Prepared by Kathrine Mische

Add PCD
File No.
AL192

32215 Big Springs Road, Yoder CO 80864 Not to Scale

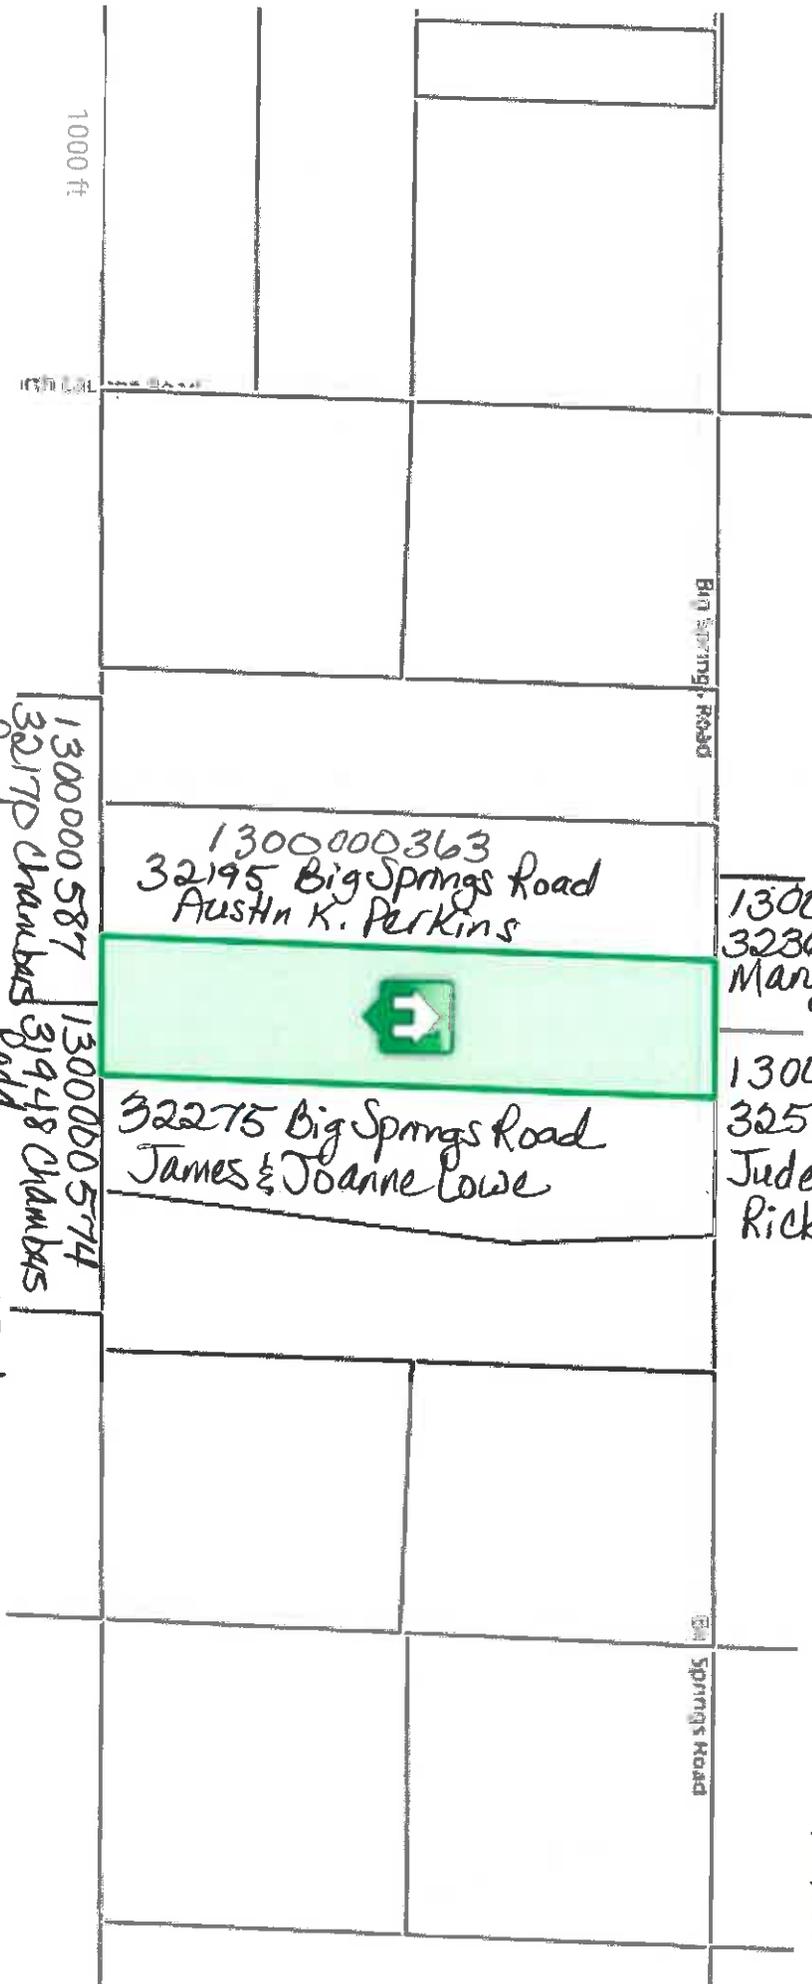
Parking lots in rural areas with fewer than 25 spaces can use rock, gravel, or other measures than pavement. The disabled space would have to meet the minimum standards for disabled spaces (ADA guidelines for universal parking design) and provide any required access aisles as required. Please show the proposed outline of the parking areas and label the proposed surface material. Even when unpaved, parking should meet the dimensional requirements of the Land Development Code Table 6-4.

Identify the building as either existing or proposed.

Label proposed location of truck loading area and/or turnaround.

Will outdoor storage be proposed? If so, please label location

Identify the surface type of the driveway and if it is existing or proposed.

If gate is proposed, provide a detail that shows material and height.

Show the distance between the gate and the edge of the road

Identify if the gate is proposed or existing
